**Rezoning Transportation Analysis**  
**Petition Number: Insert Zoning Petition #2021-161**  
*General Location Identifier: 22902119*

**Revision Log:**

Date	Description
08-20-2021	First Review (WB)
09-17-2021	Second Review (WB)
10-18-2021	Second Review (WB)
11-22-2021	Fourth Review (AO)
12-23-2021	Fifth Review (AO)

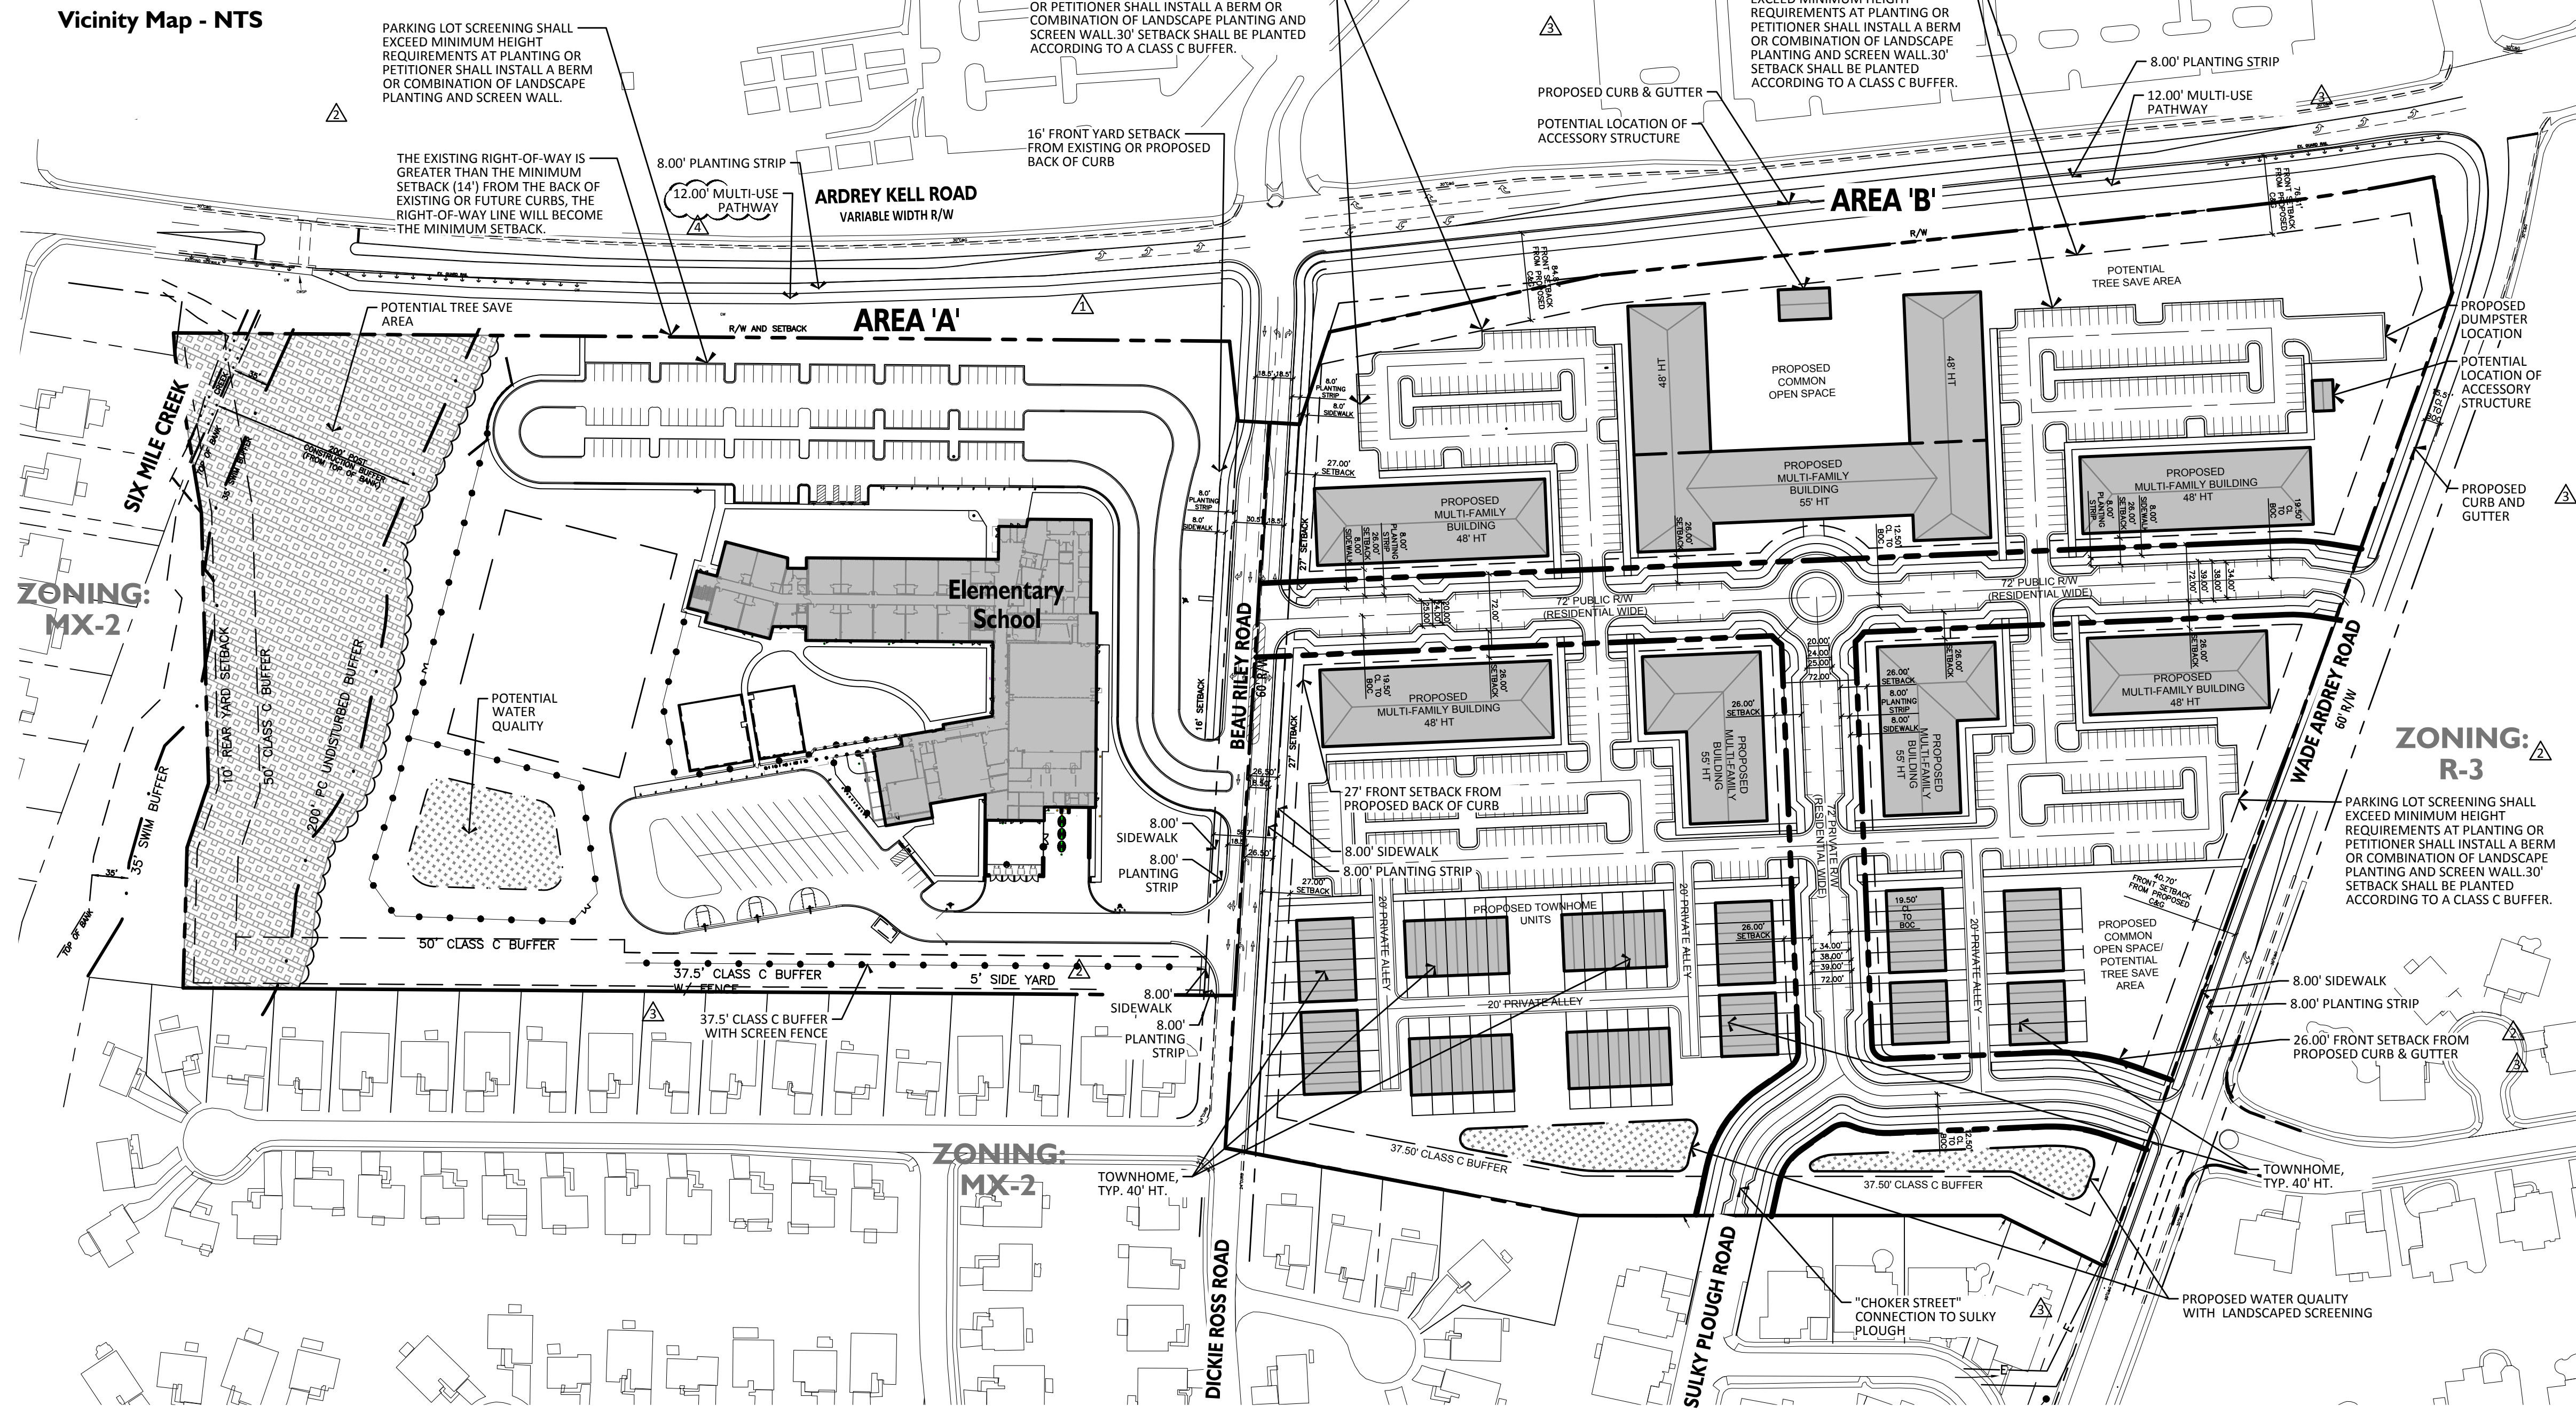
**Update to Comment from 11/22/21:** (site plan dated 12-13-2021): ~~Charlotte BIKES policy requires bikes to be accommodated along Ardrey Kell Road. Provide a 12' Multi-Use path along entire frontage on Ardrey Kell Rd.~~ Add conditional note committing to constructing the multi-use path along entire frontage on Ardrey Kell Road as depicted on the site plan.

8. **New comment (site plan dated 12-13-2021):** Revise site plan and conditional note(s) committing to pedestrian safety crossing on Wade Ardrey Road at Woodland Watch Court. Crossing type and location to be coordinated with NCDOT and CDOT.
